Your Ref
AL/117/12
Our Ref
PLAN-002128
Date
08/01/2013

Proposal: Change of use of land for the siting of a second mobile home and storage of two caravan units for Travelling Show Persons.

Site: The Old Barn, Arundel Road, Fontwell BN18 0SX.

Mr. J. Horton			
The Old Barn, Arundel Road, Fontwell. BN18 0SX			Richard Stubbs MRTPI
Mobile Home (2nd) and 2 Caravans			TEL: 01243 825944
1:2500 1:500 November 2012			06/12 1 of 1

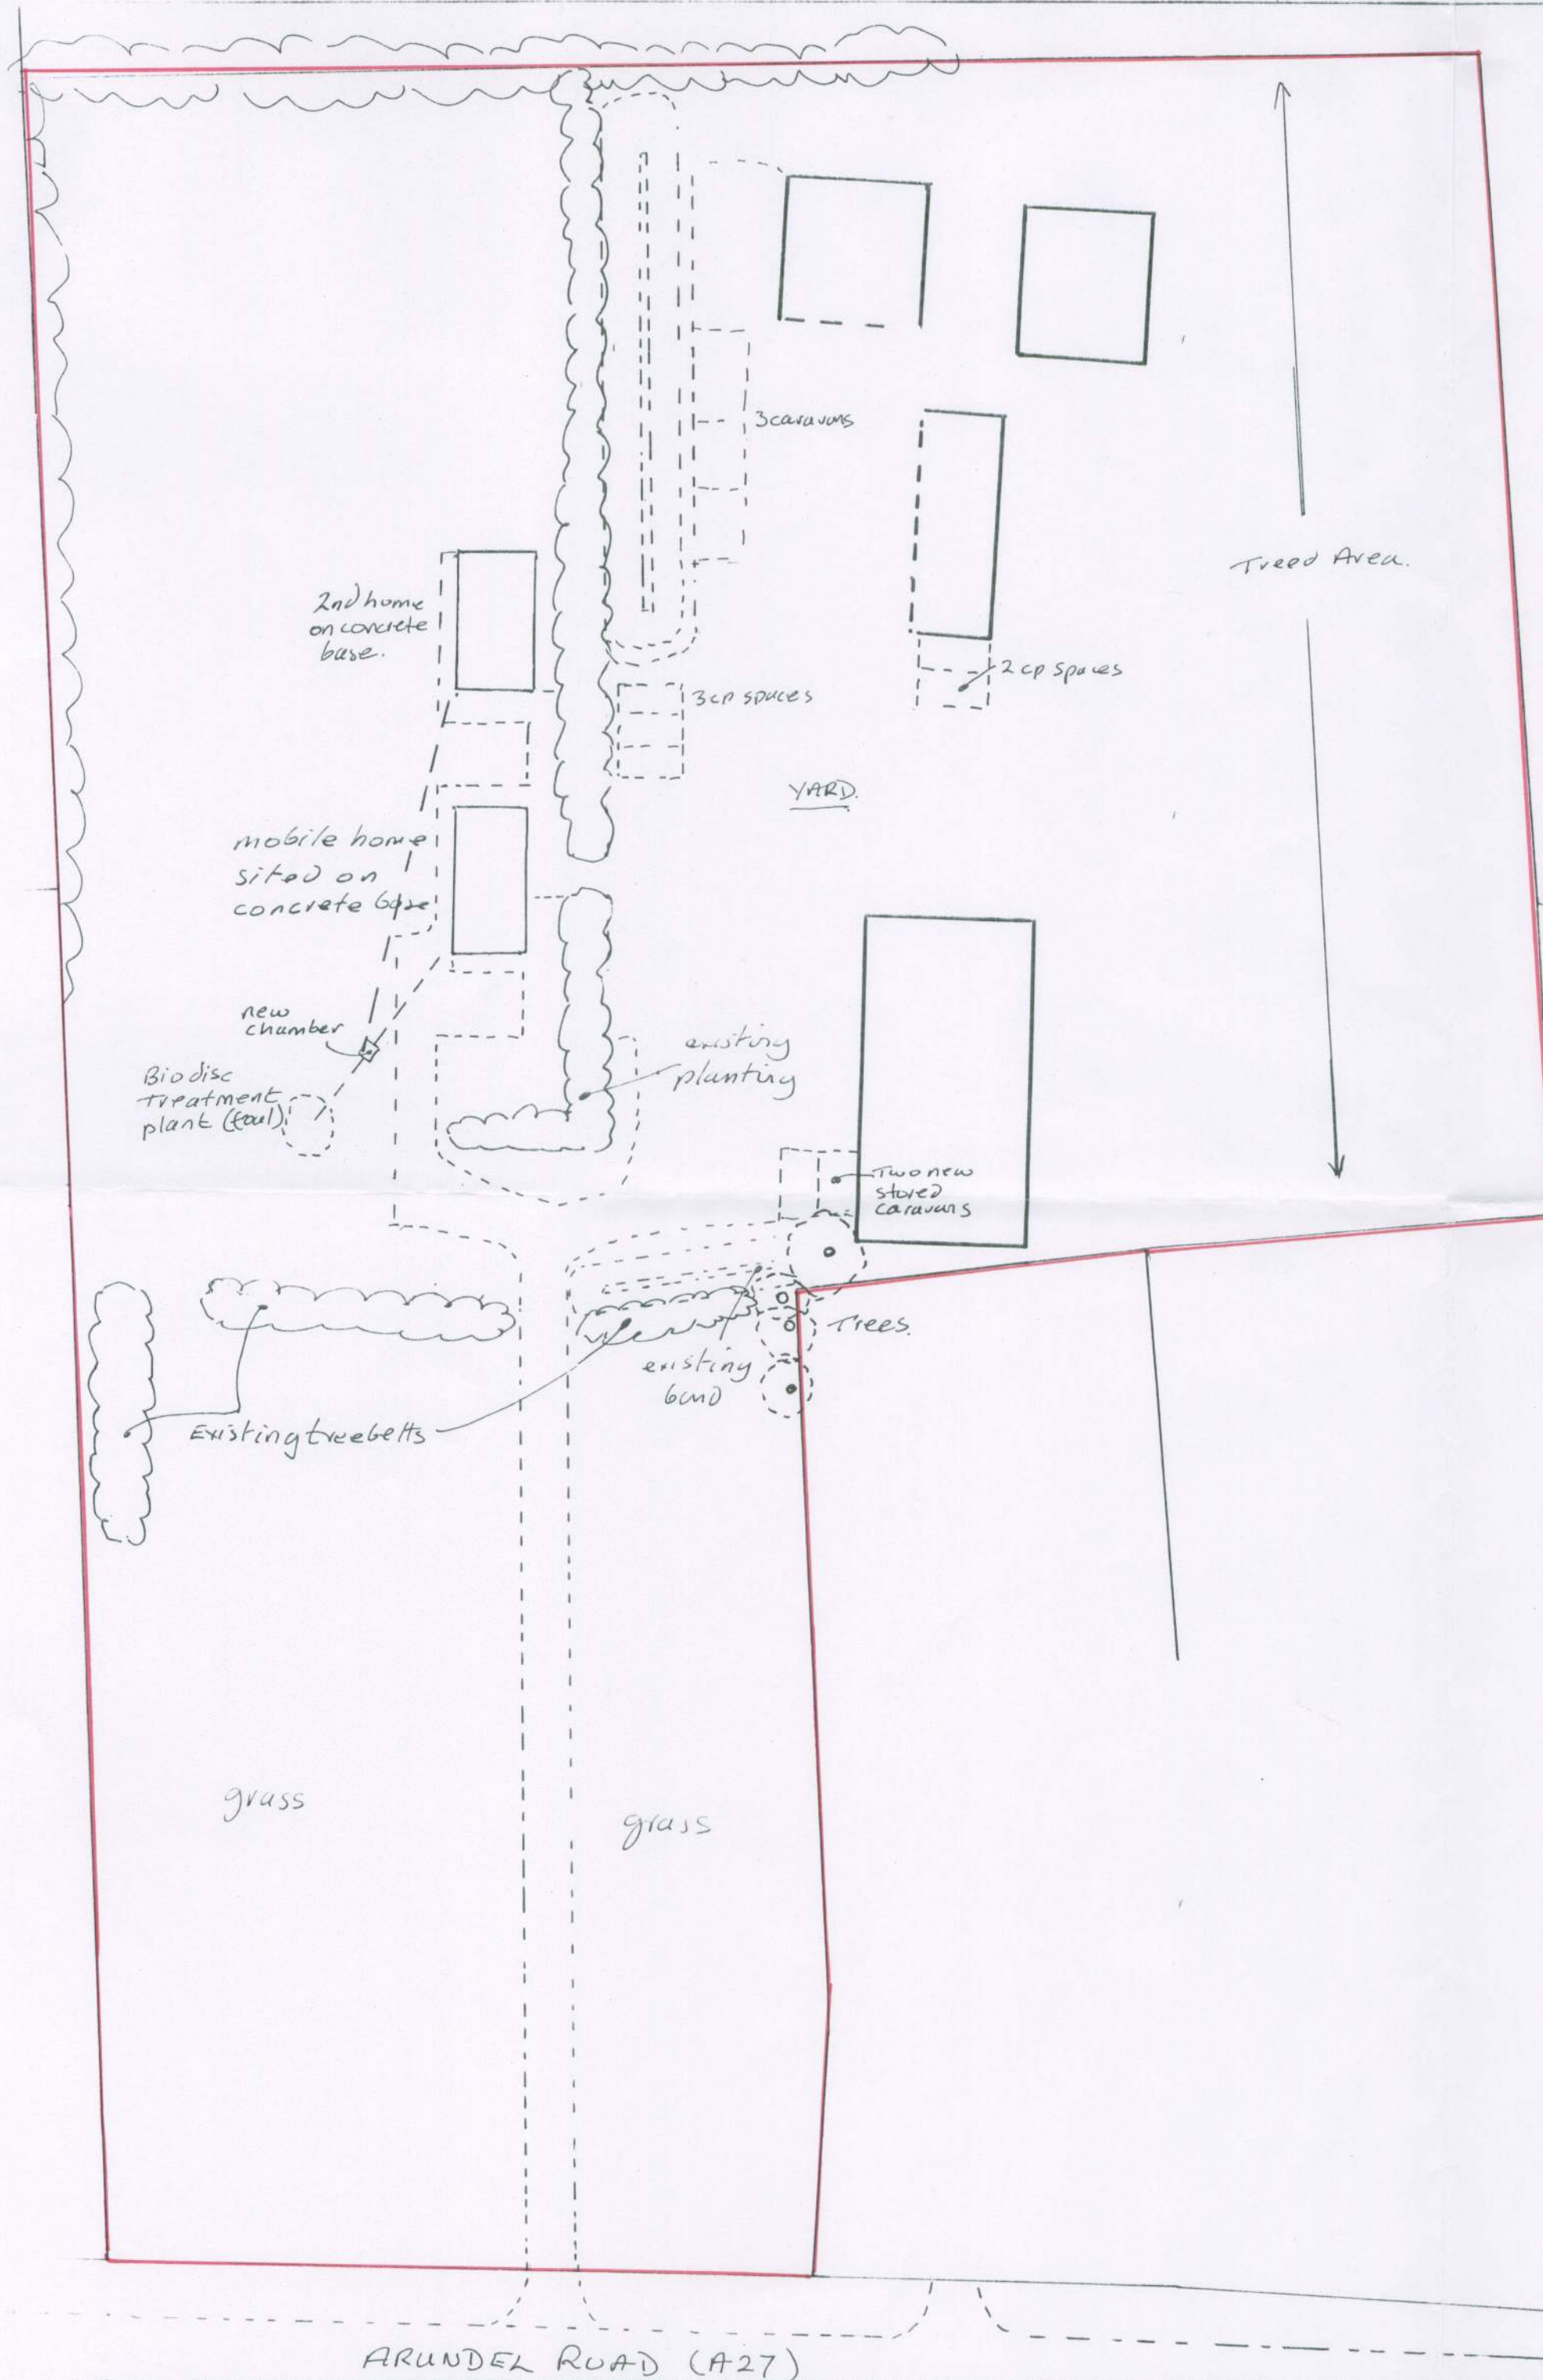
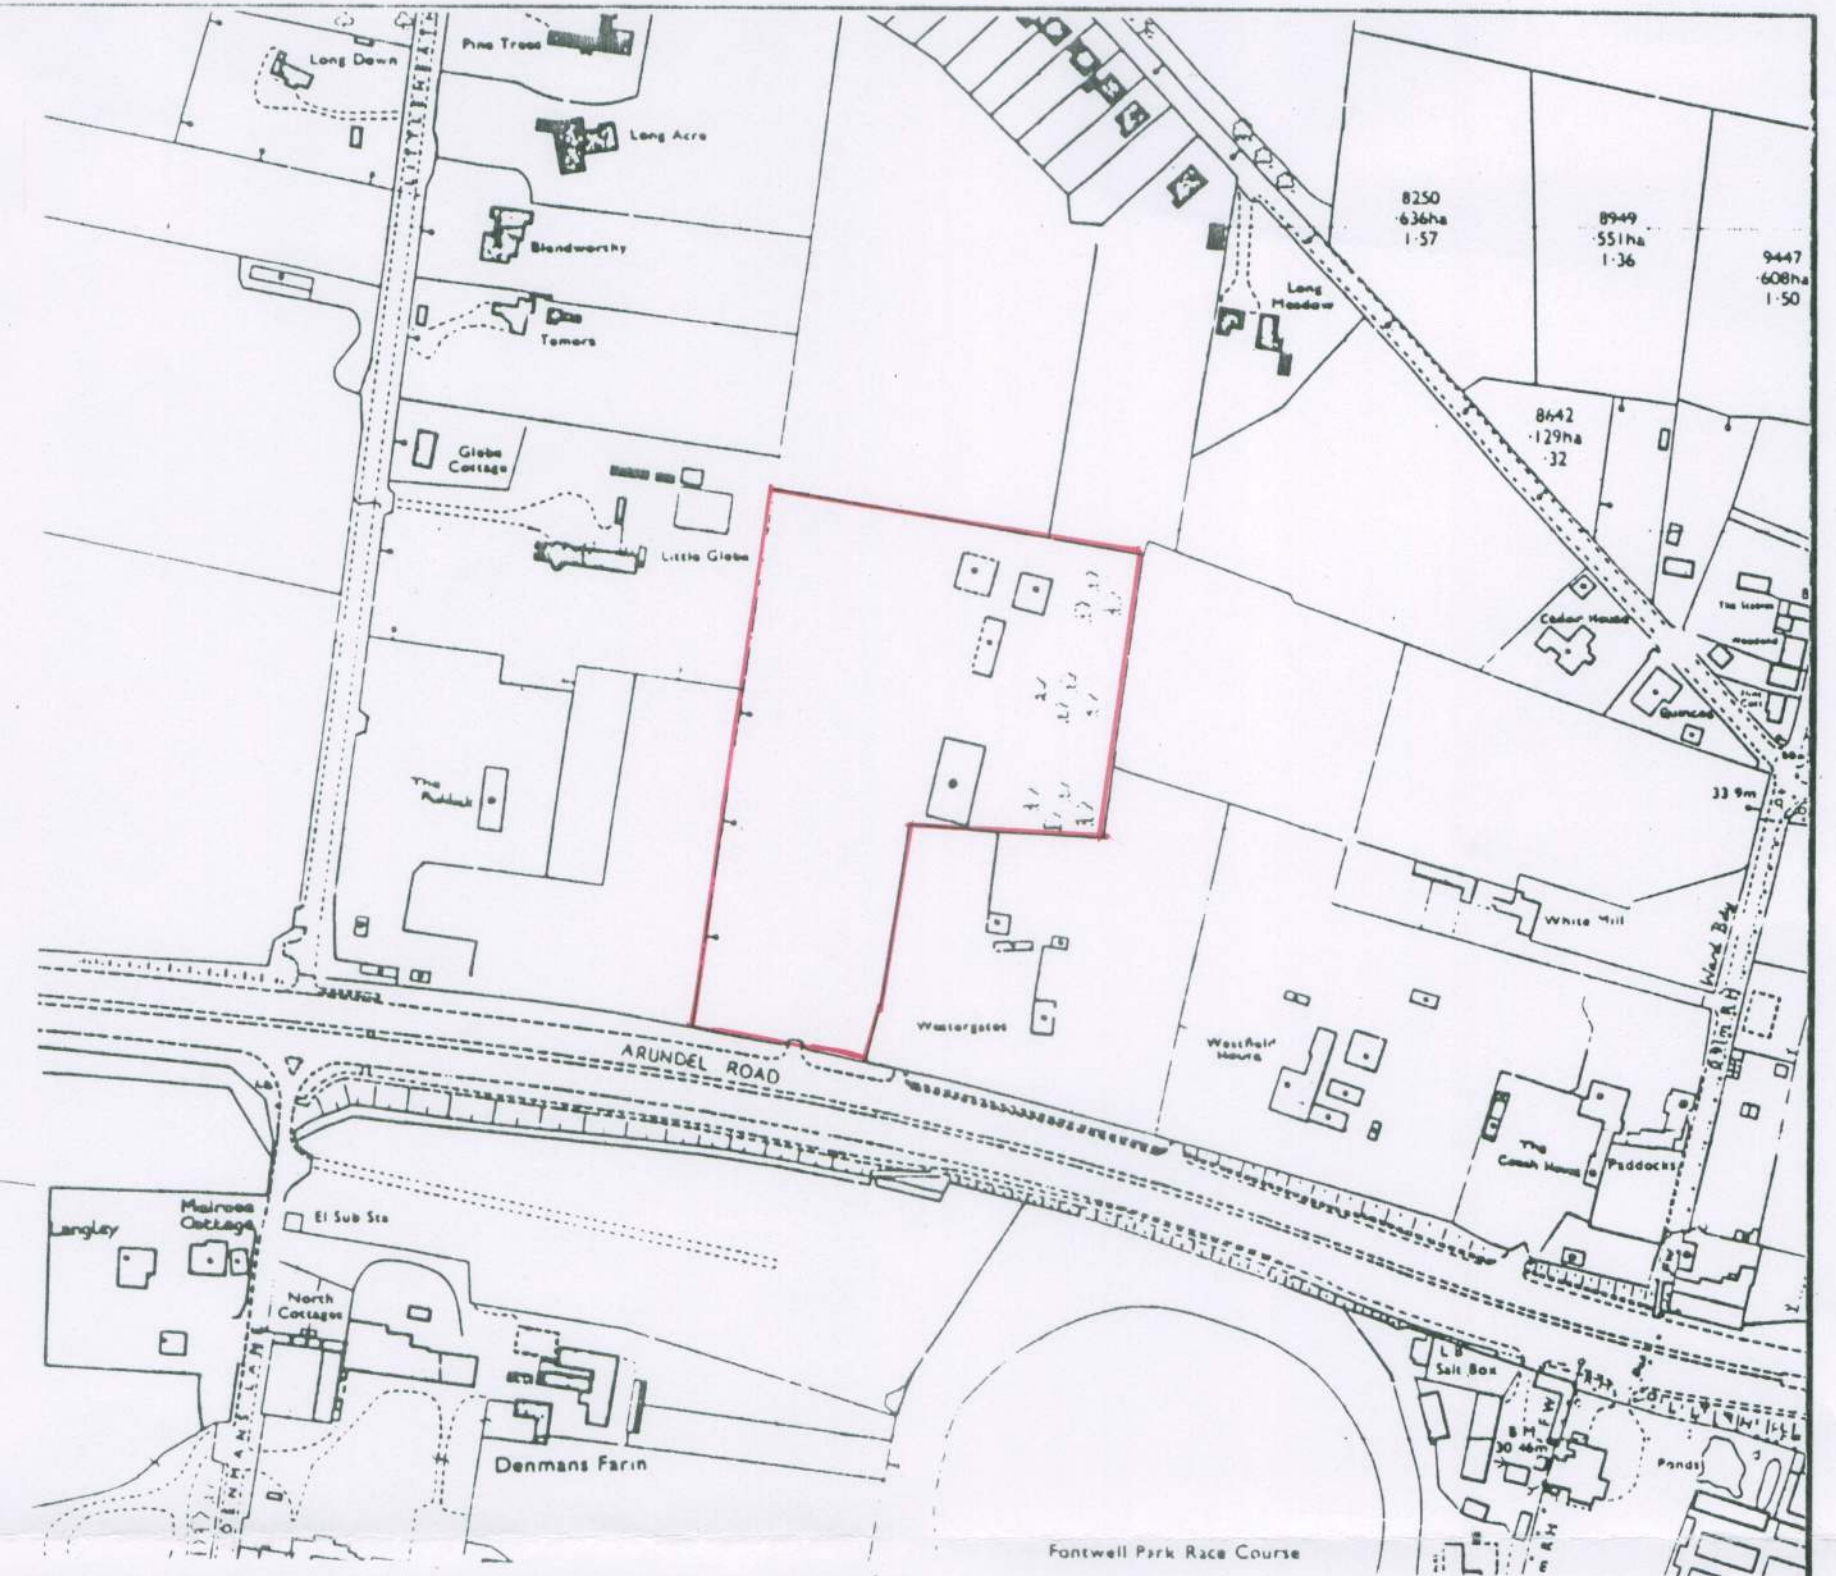
The applicant is advised to consult the Environment Agency directly regarding the use of a package treatment plant which disposes of effluent to sub-soil irrigation. The owner of the premises will need to maintain the works to ensure its long term effectiveness.

The applicant has not stated details of the proposed means of disposal of surface water from the site. This should not involve disposal to a public foul sewer.

There are no public surface water sewers in the area to serve this development. Alternative means of draining surface water from this development are required. This should not involve disposal to a public foul sewer.
